DEVELOPMENT REVIEW BOARD
SUPPLEMENTAL SUBMITTAL

PROJECT NO. PR-2021-006070

Application No. SI-2021-01889

Re: Westpointe40 North Site Plan DRB Comment Responses (PR-2021-006070)

**NORTH SITE PLAN**

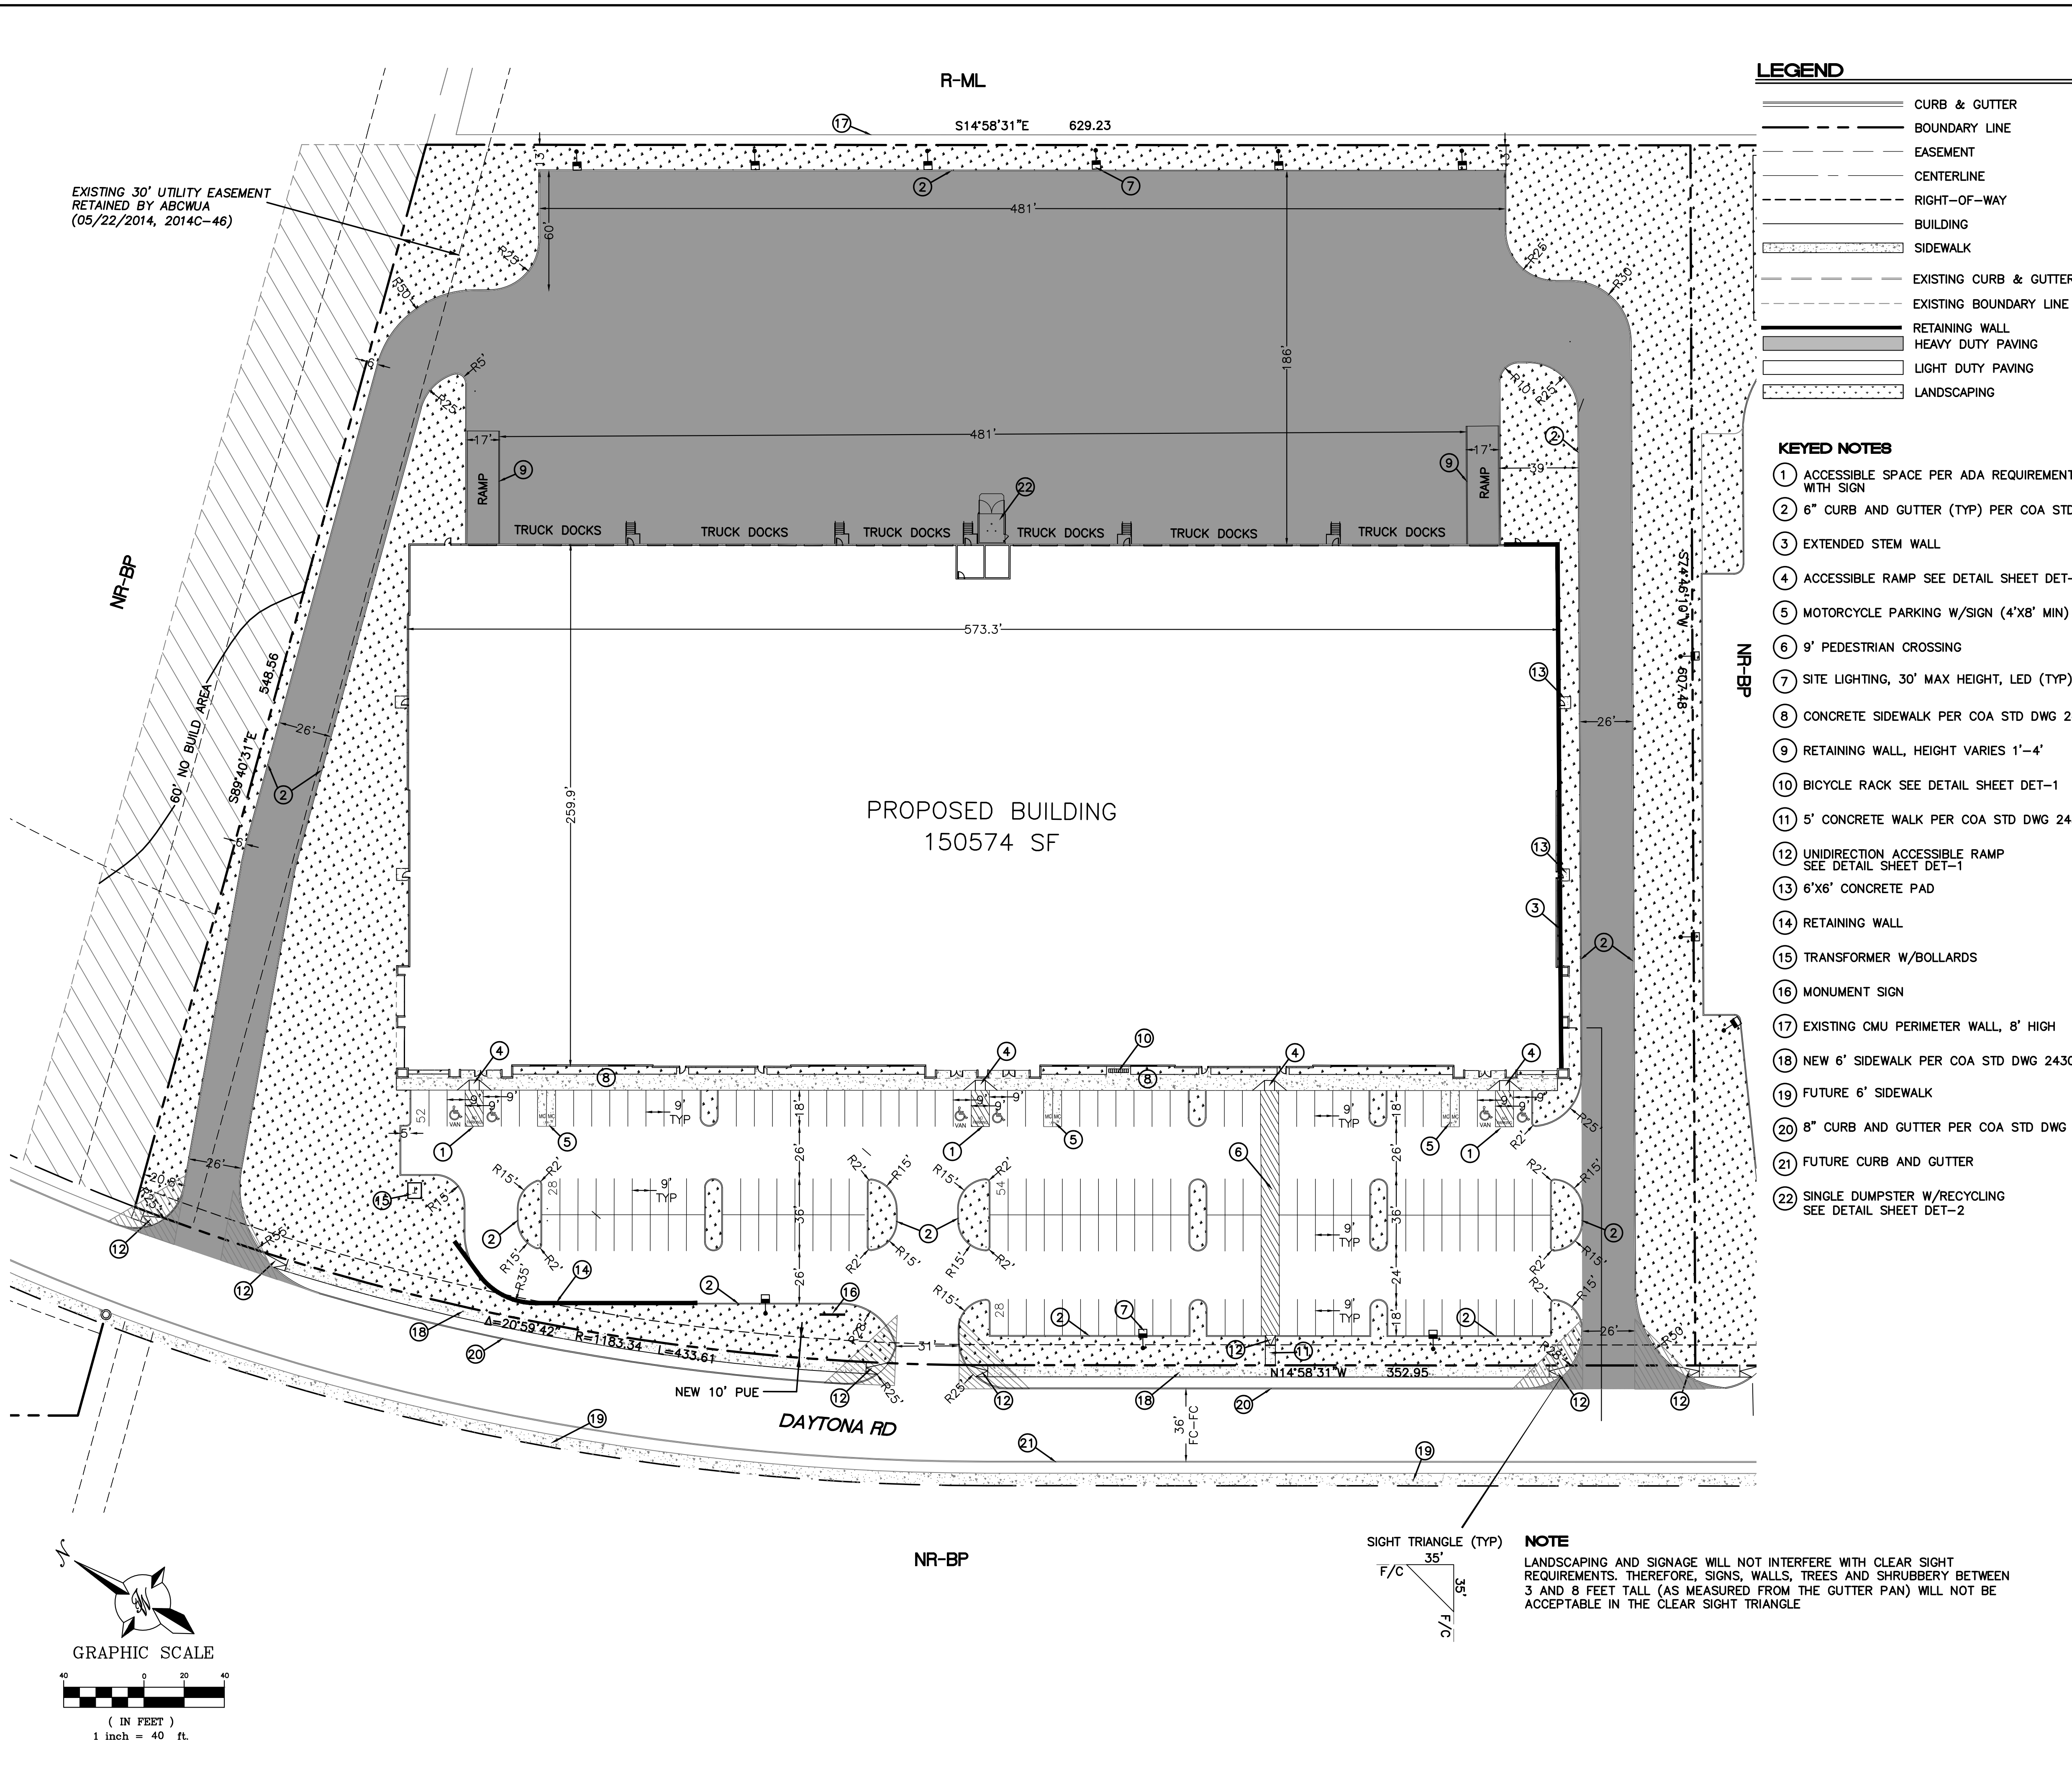
- *Understood. The project has been designed to comply with the NR-BP zone district regulations.*
3. Dimensional standards per IDO section 5-1. Clarify different setback notes on plat.

5. Landscaping Edge Buffer per 5-6-E, table 5-6-4. Please clarify use. Non-Residential or Industrial require different standards.
 - *While this building is a spec building and may primarily house warehousing, wholesale, and distribution uses, the applicant has reconfigured the site plan to provide a 25-foot landscape buffer consistent with the industrial standards. This will allow flexibility in leasing and future uses that can utilize the proposed building.*

2. Provide a 6-foot ADA pathway from the building to the right-of-way.
 - *The pedestrian connection has been updated with the required width (Keynote 11).*

1. The warehouse is an industrial use and will require a landscaped edge buffer area at least 25-feet in width along all boundaries with non-industrial development. The North Site Plan has multi-family on the eastern boundary. The South Site Plan has multi-family on the eastern boundary and single family on the southern boundary (please see the attached comments on Industrial Buffers). On the South Site Plan, a landscaped edge buffer area at least 15-feet in

- *Please see the response to Code Enforcement comment #8.*
5. The building setbacks are depicted on the Site Plan as 5-feet for the front, and 0-feet for the sides and rear. The setback requirements in the NR-BP zone district are 20-feet for the front, and 10-feet for the sides and rear. The setbacks for the buildings based on the NR-BP standards appear to be met. Confirm that the setbacks are being met and note the correct required setback standards and the setbacks for the proposed buildings on the Site Plans.

- *The setbacks on the site plan have been updated to correctly reflect the NR-BP zone district standards, and the plan complies with these setbacks.*

- a. A 25-foot buffer has been created on the east side of the site.
2. The project and application numbers need to be added to the Site Plan prior to distribution of the Site Plans to the DRB members for their e-signatures.

- *The setbacks have been updated on the site plan.*

**NORTH SITE BUILDING ELEVATIONS**

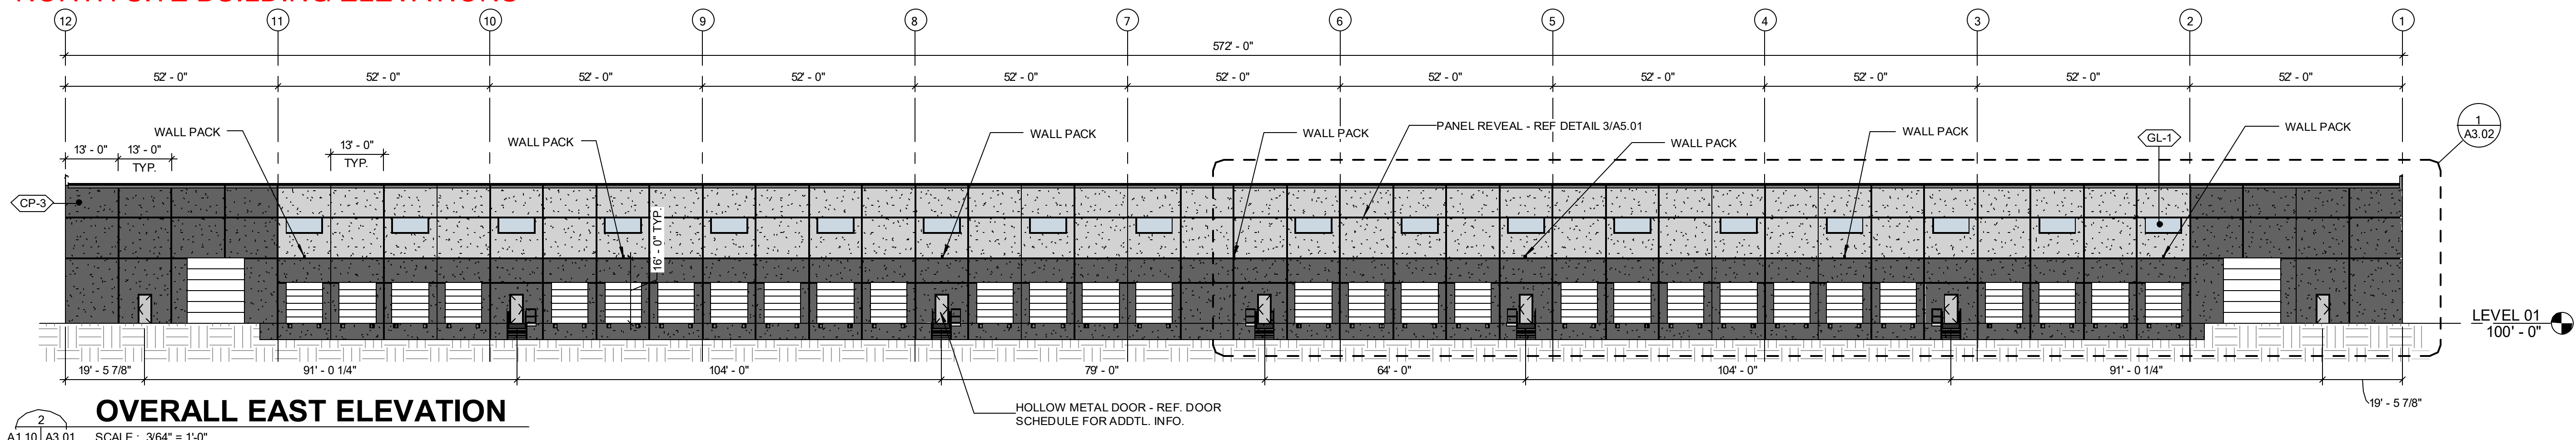
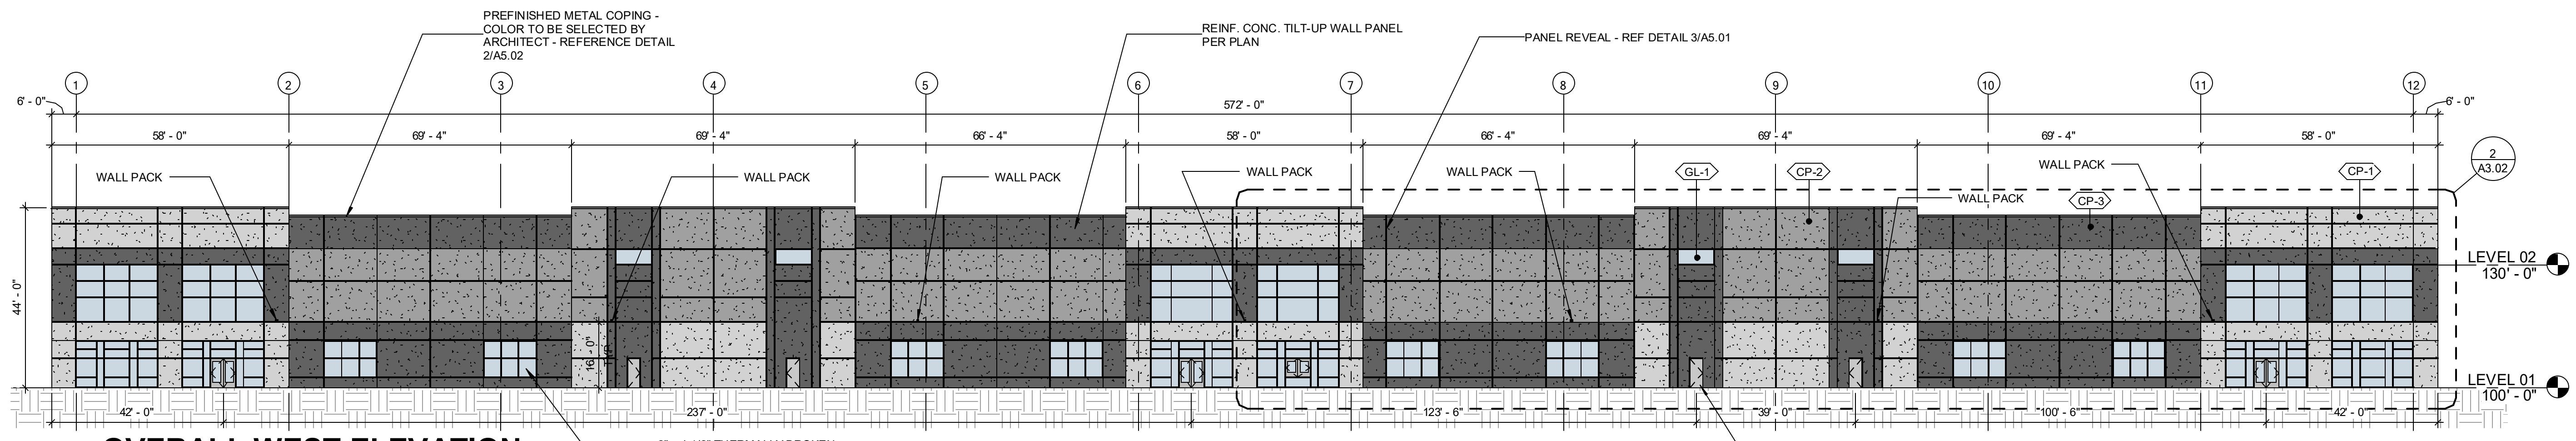
8. Additional detail needed for meeting Façade Design general standards, IDO section 5-11-E.
 - *Despite the large size and function of the building, a human scale is provided along the primary building façade through a differentiation in colors and use of windows and doors around entries.*

4. The applicant must confirm that the Façade Design requirements of 5-11(E) of the IDO are being met in a comment response letter and how they are being met.

- *The building is setback more than 30 feet from Daytona Road, so it does not meet the definition of a street-facing façade and therefore is not required to meet the standards outline in Section 5-11(E)(2)(a)2. However, the applicant has taken care to provide visible primary pedestrian entrances and the use of ground floor windows to improve the overall look and feel of the building from the parking lot.*

- *While it is not considered a street-facing façade, the west elevation breaks up its length using a change in parapet heights and building articulation every 60 to 70 feet, as well as using multiple colors along the entire length of the façade.*

## SHEET #4- UTILITY PLAN

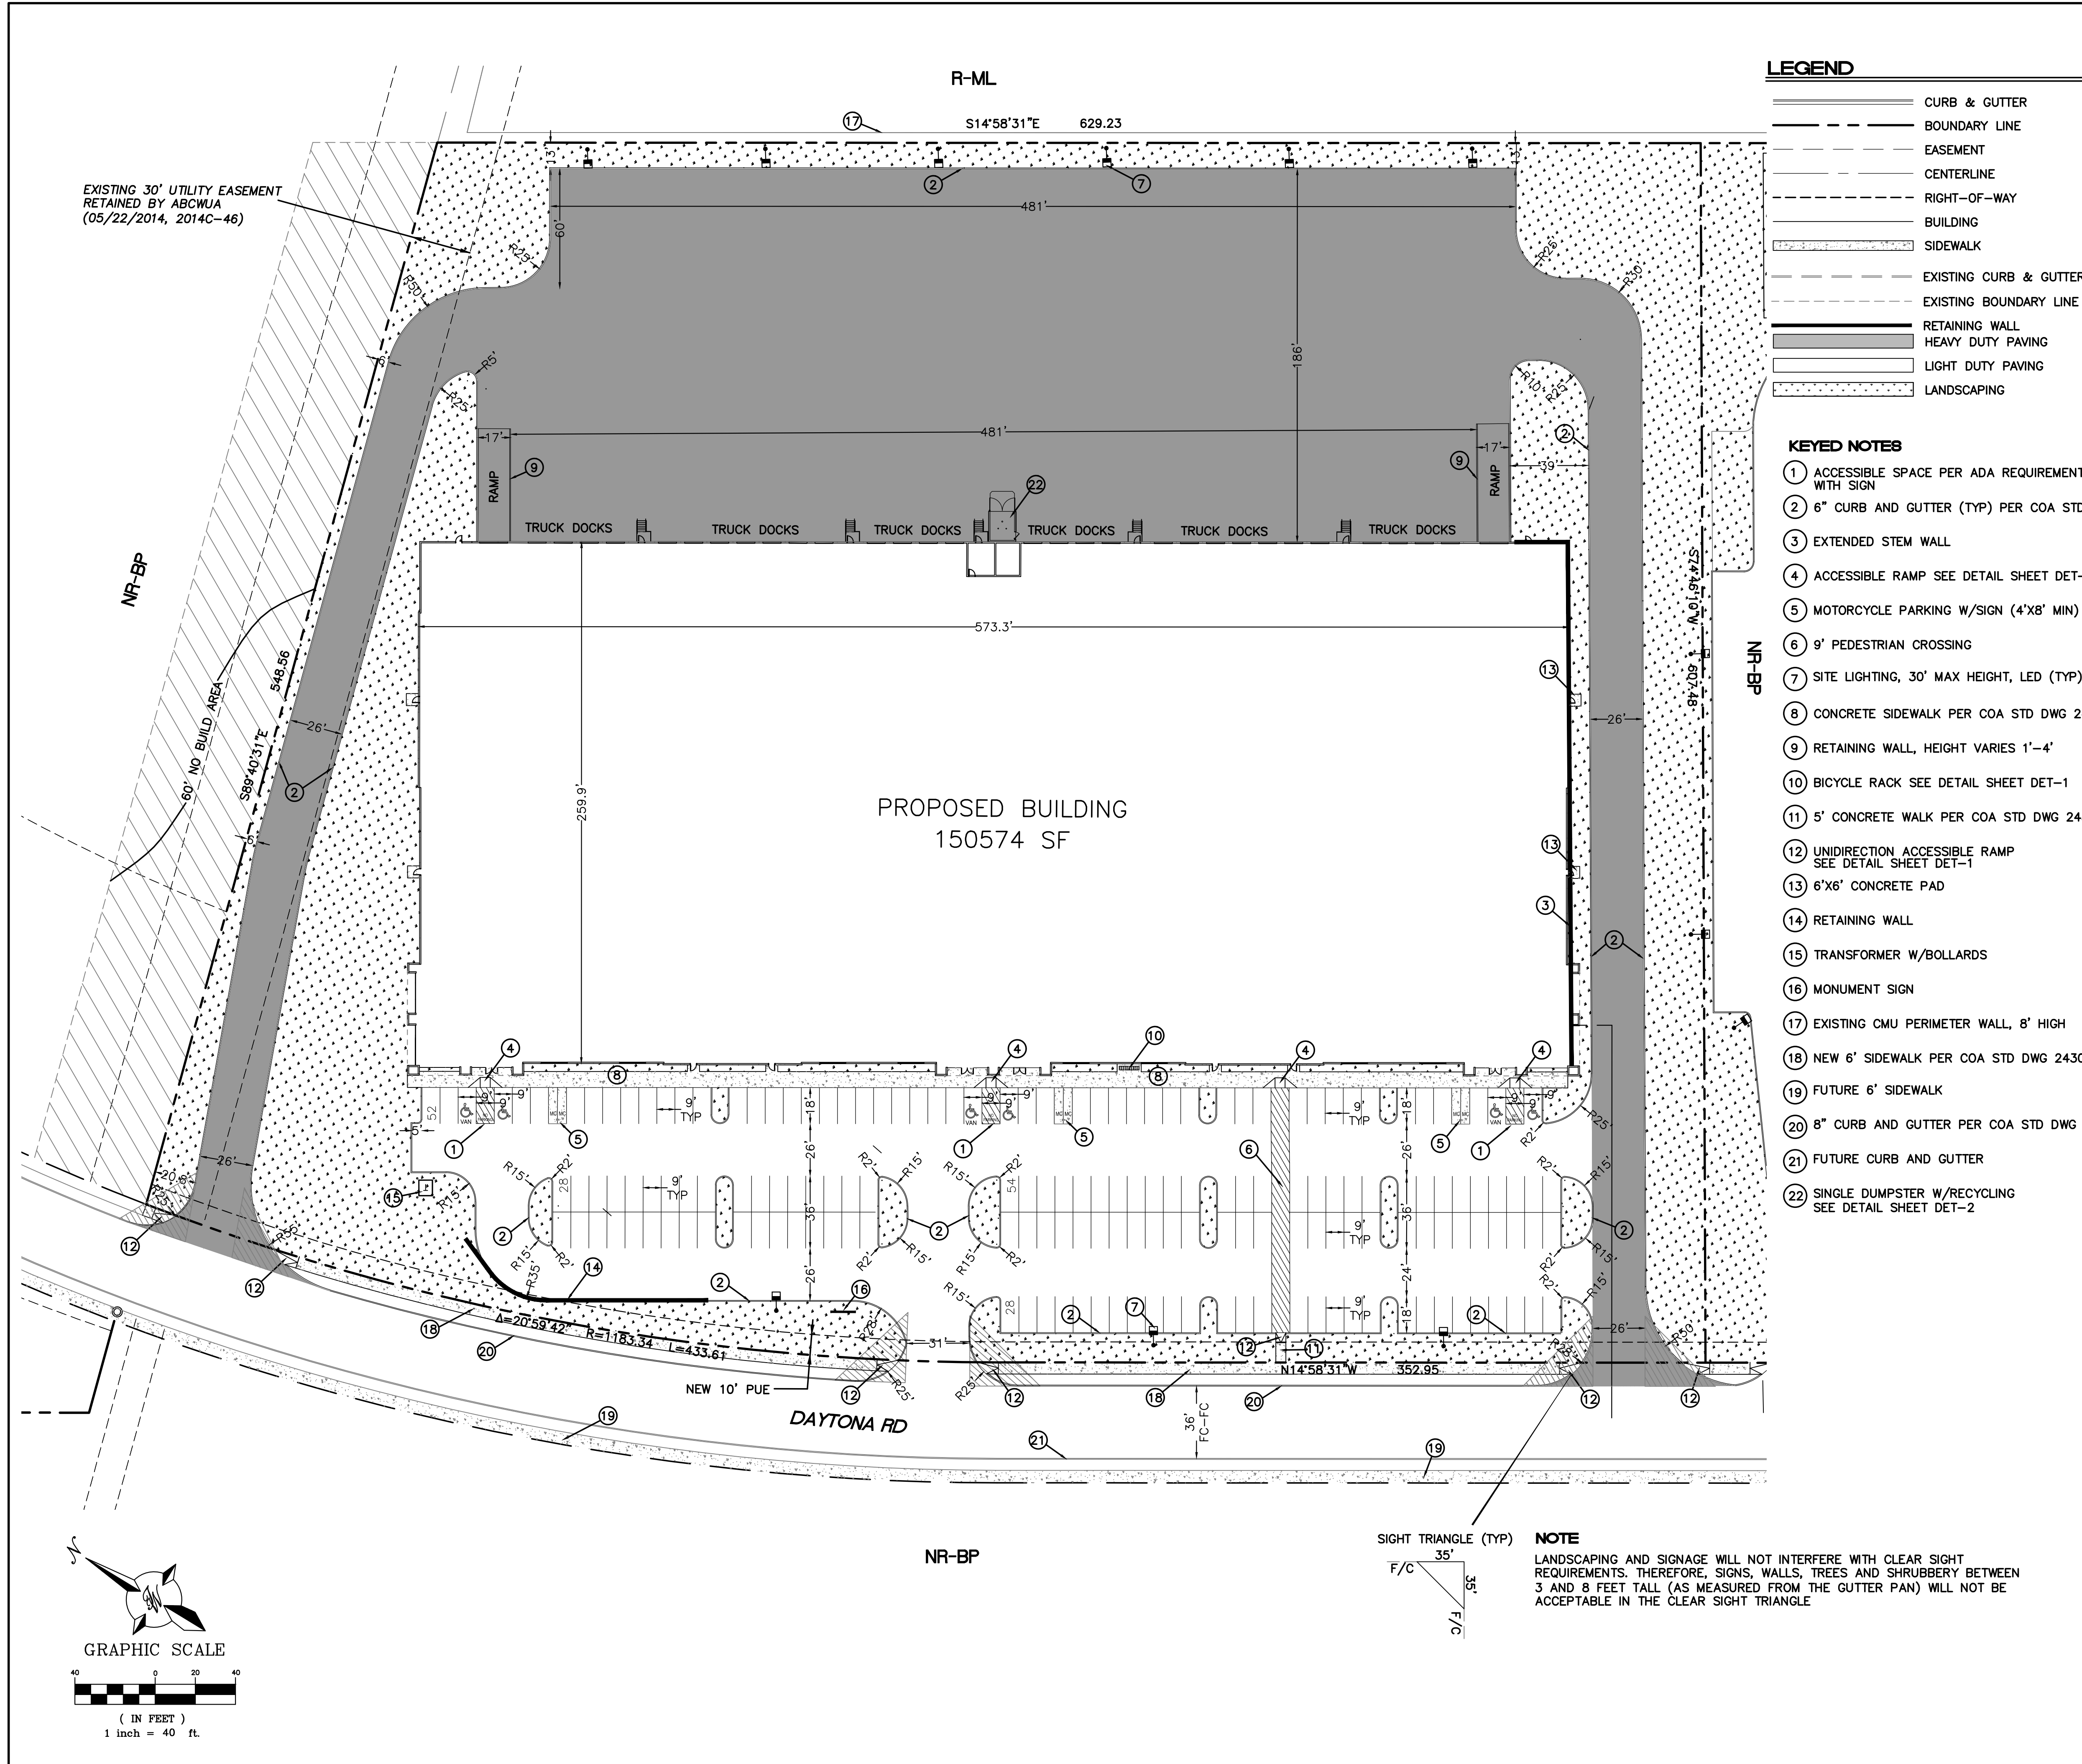
2. This project is within the adopted service area.
3. Pro rata is not owed for this property.
4. Utility Plan:
 - a. The meters need to be at the right-of-way line. The WUA will not maintain a line onsite to shorten the private water line lengths.

- b. The proposed public hydrant needs to be within the right-of-way or within a public water easement. Please revise accordingly.
 - c. The required water main has been revised to a ten-inch. Please revise the call-out to be consistent with this requirement.

- d. One of the four required hydrants is to be on the parcel to the south. Please provide some sort of agreement or easement that will enable this site to utilize that offsite hydrant.

- *An updated utility plan has been provided with the supplemental submittal.*
5. Infrastructure List:
 - a. The improvements required in the Availability Statement shall be incorporated into the infrastructure list.
